**Oakdale West Estate Stage 3 Development (SSD-9794683)  
Request for additional information**

## **Attachment 1 Department's Comments on the RtS**

| DRAWING LIST |                           |
|--------------|---------------------------|
| DA20         | SITE PLAN                 |

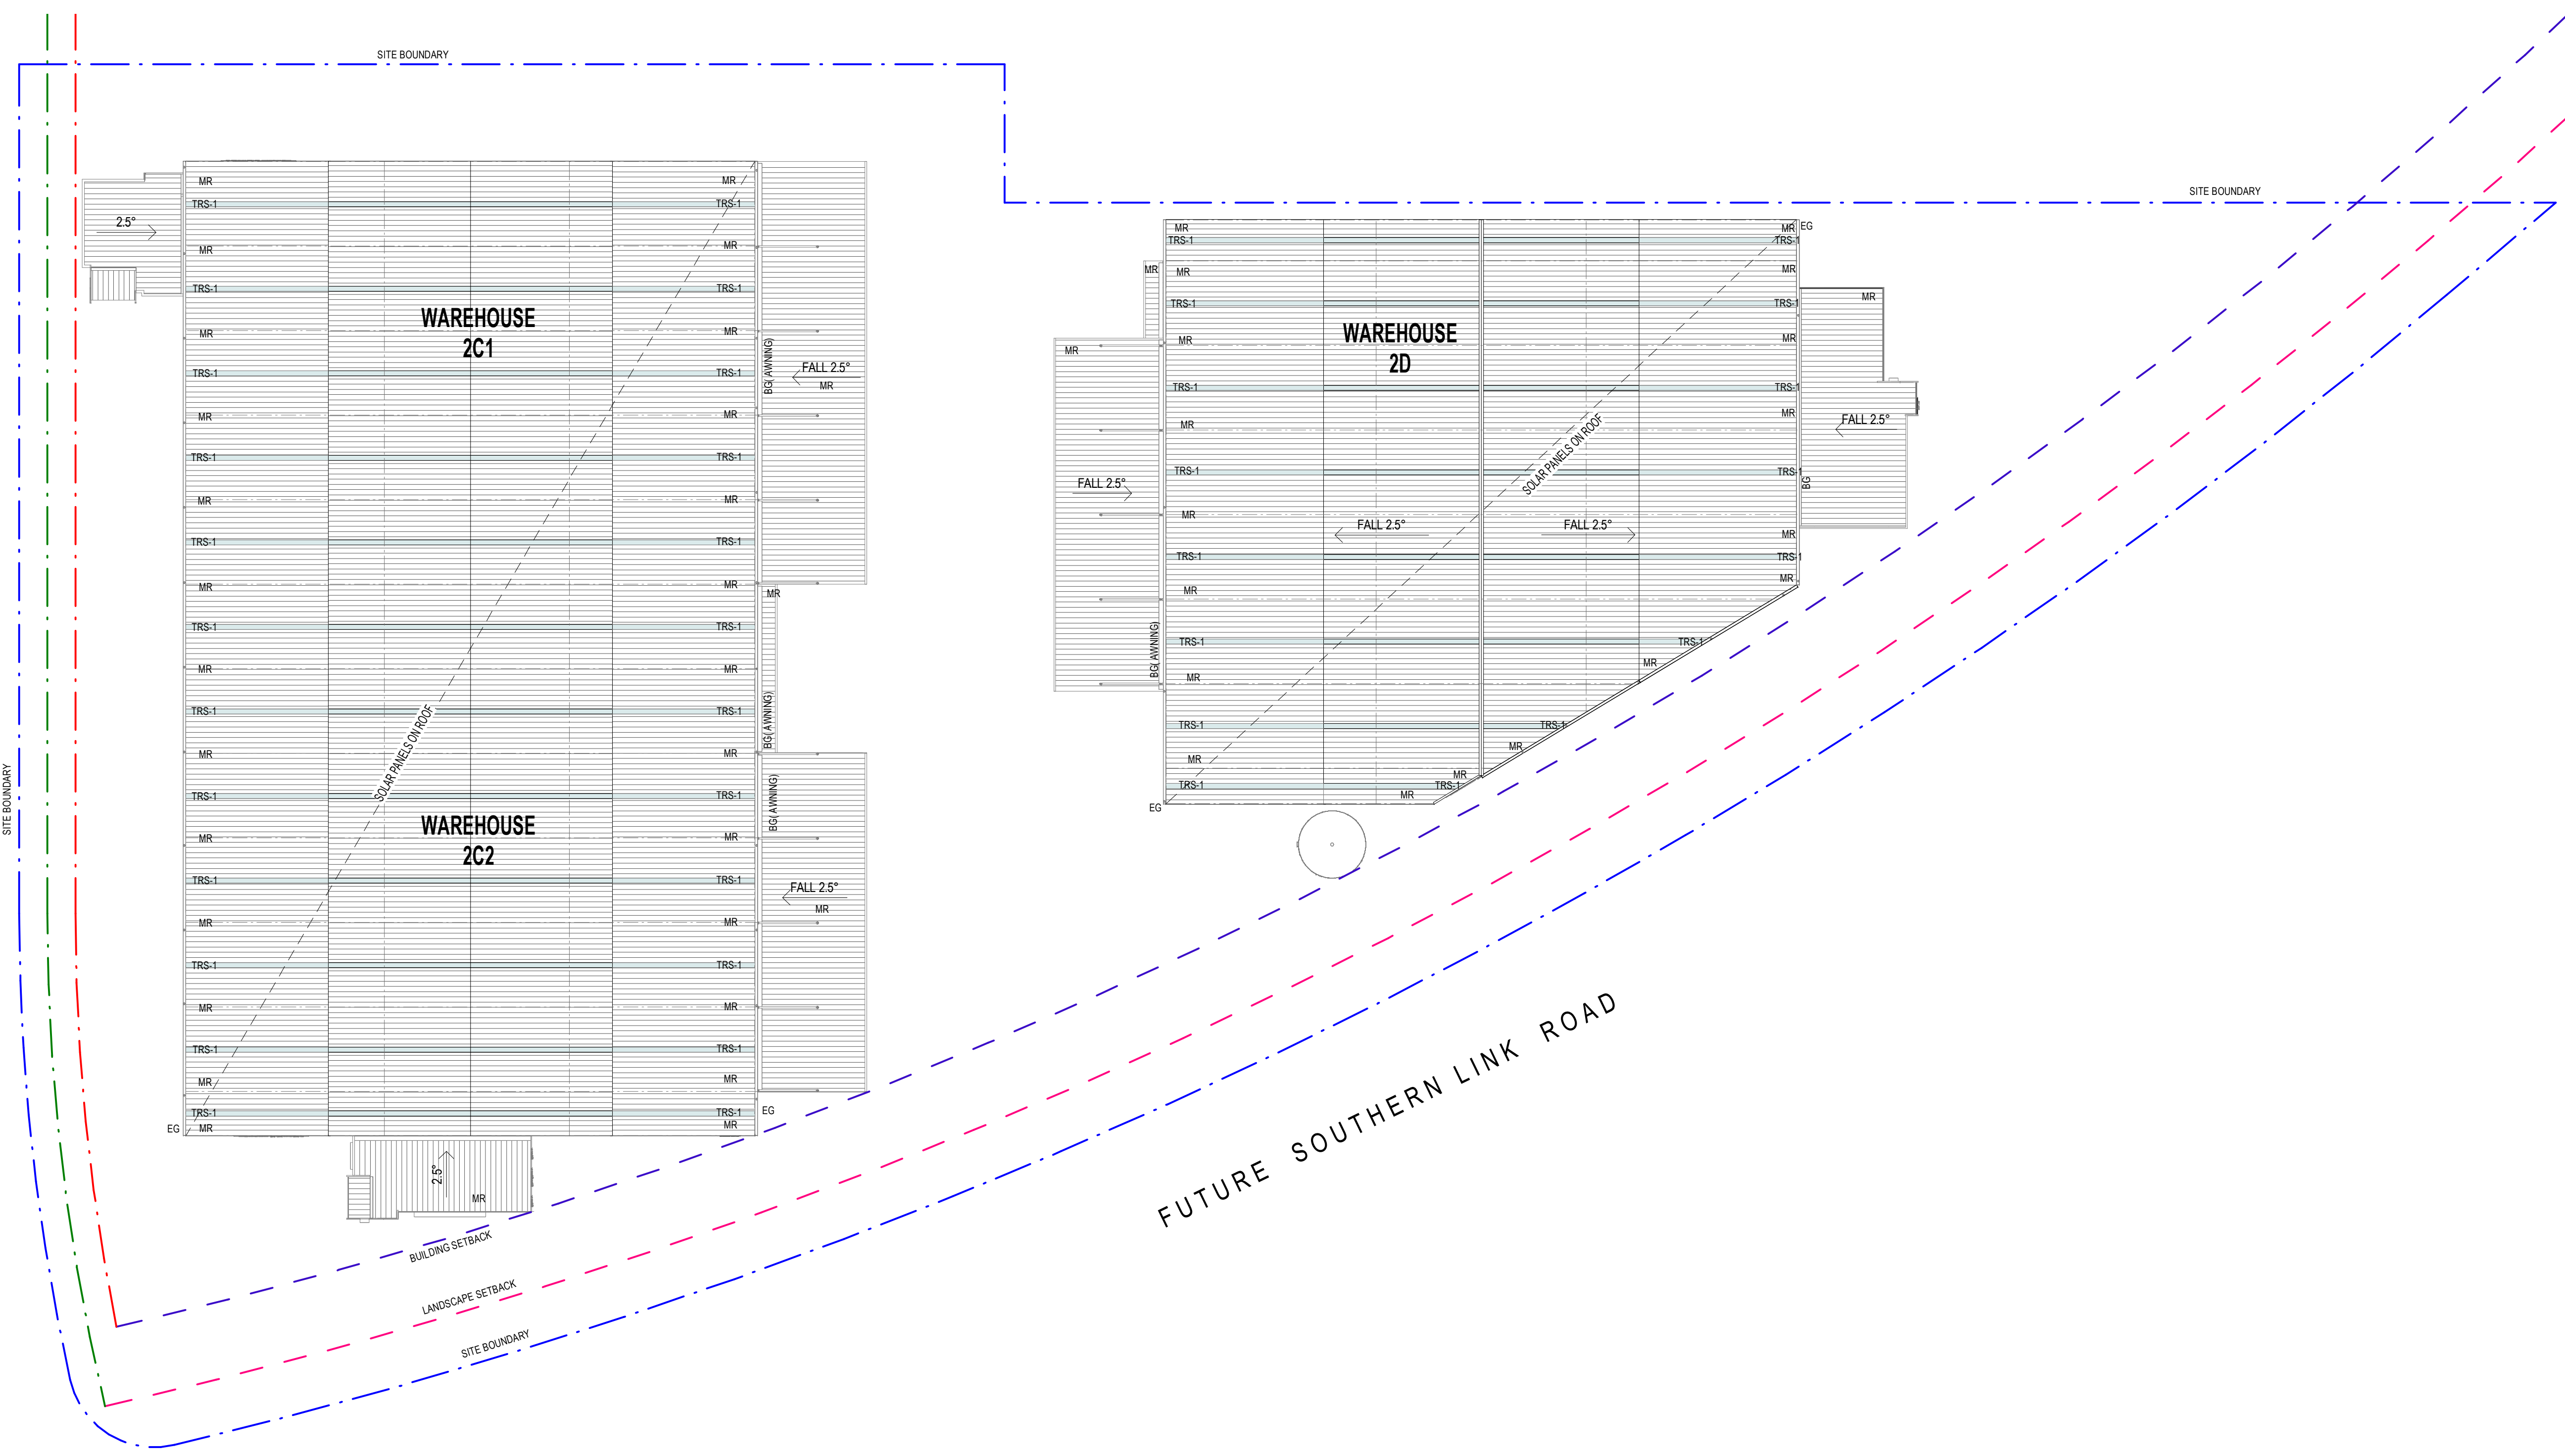
The Department notes that a shared light and heavy vehicle driveway is proposed for access to the Building 2D car park. The Department agrees with Council that this has potential traffic safety impacts along the driveway and within the loading dock area. It is requested that an alternative access arrangement be provided for light vehicles to the car park, noting that landscape setbacks along each boundary must be maintained.

1 ELEVATION WEST - WAREHOUSE 2C 1 : 250

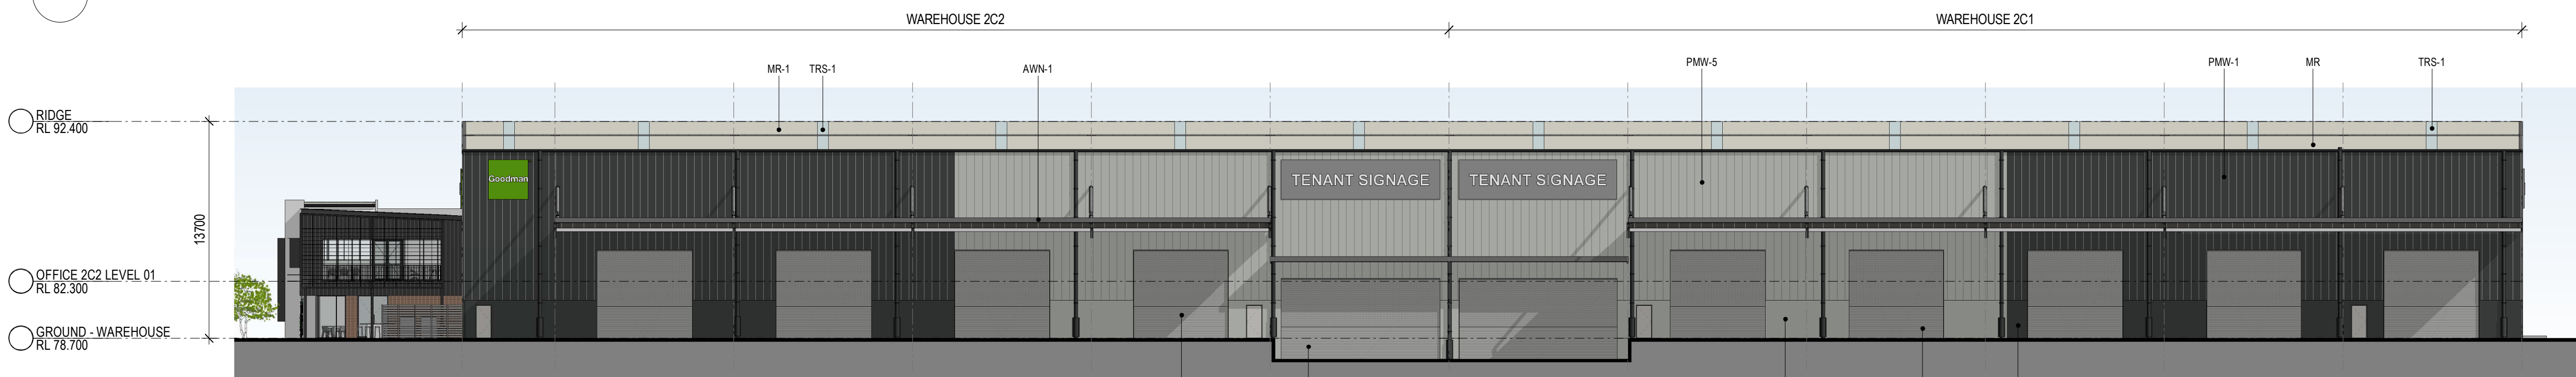
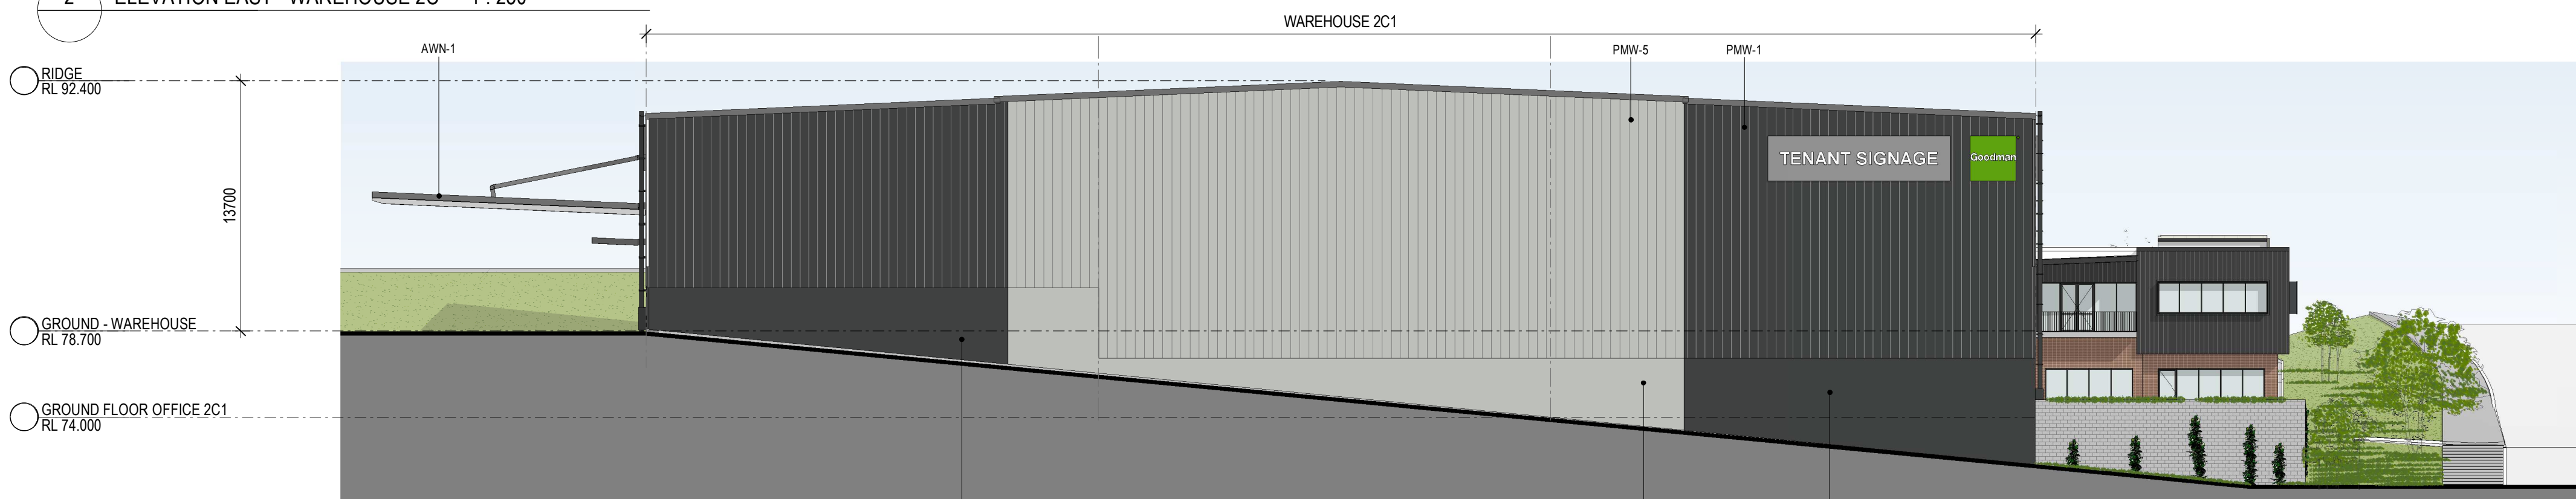
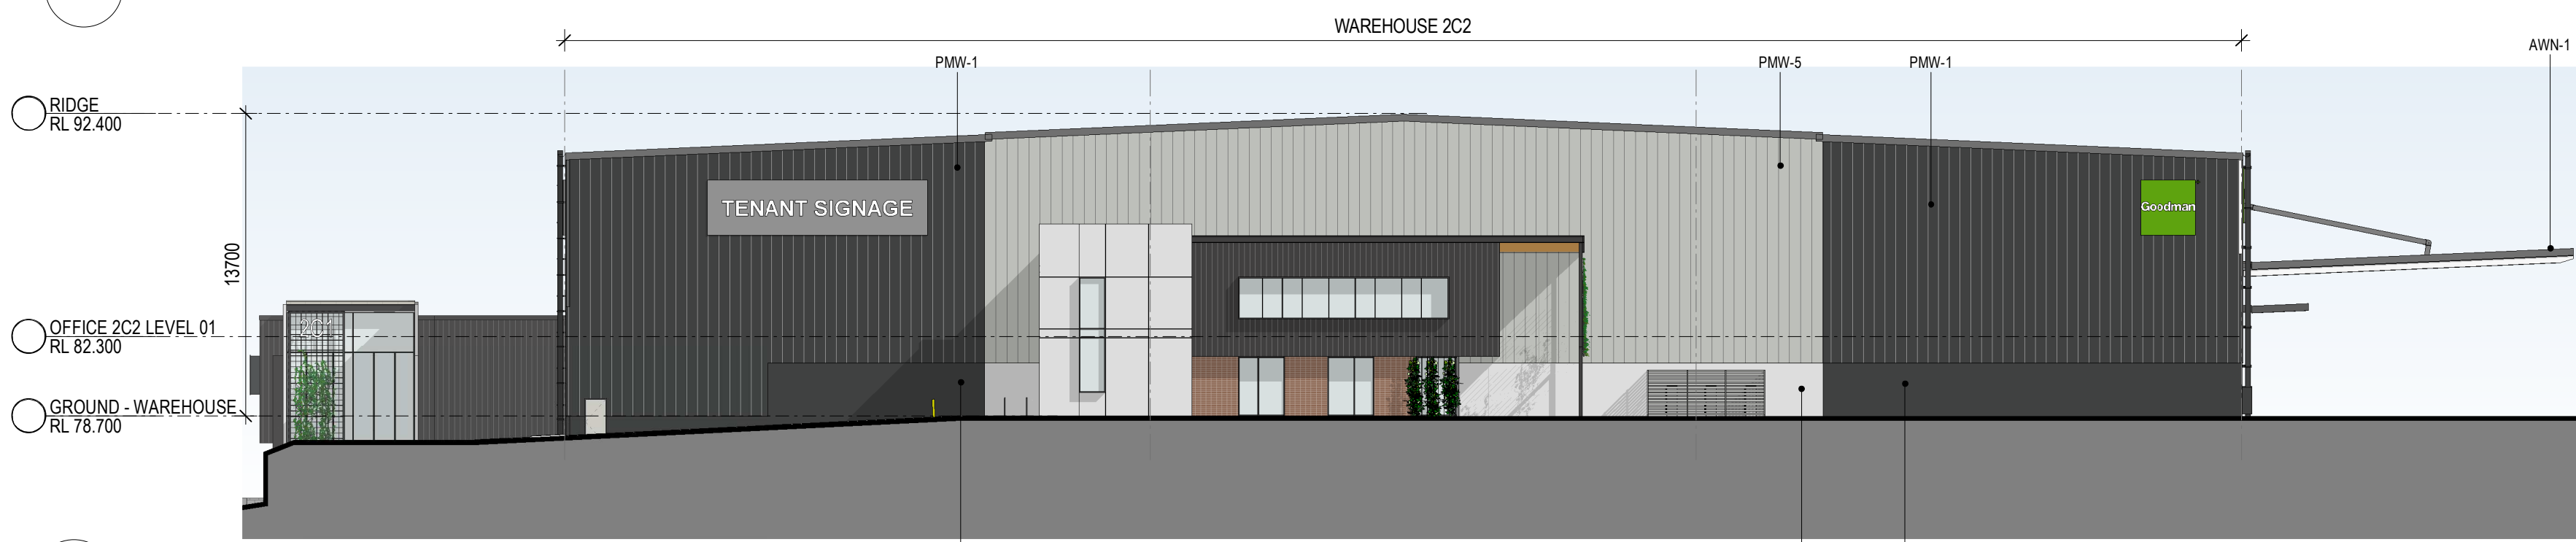
The Department notes that the effective height of Building 2C is approximately 22.2 m when measured from the base of the wall on the western elevation. This exceeds the maximum building height limit of 15 m in Condition B10 of SSD-7348. For the Department to consider the proposed variation, a modification application is required to amend Condition B10. This should be supported by a strong justification and an assessment of potential impacts.
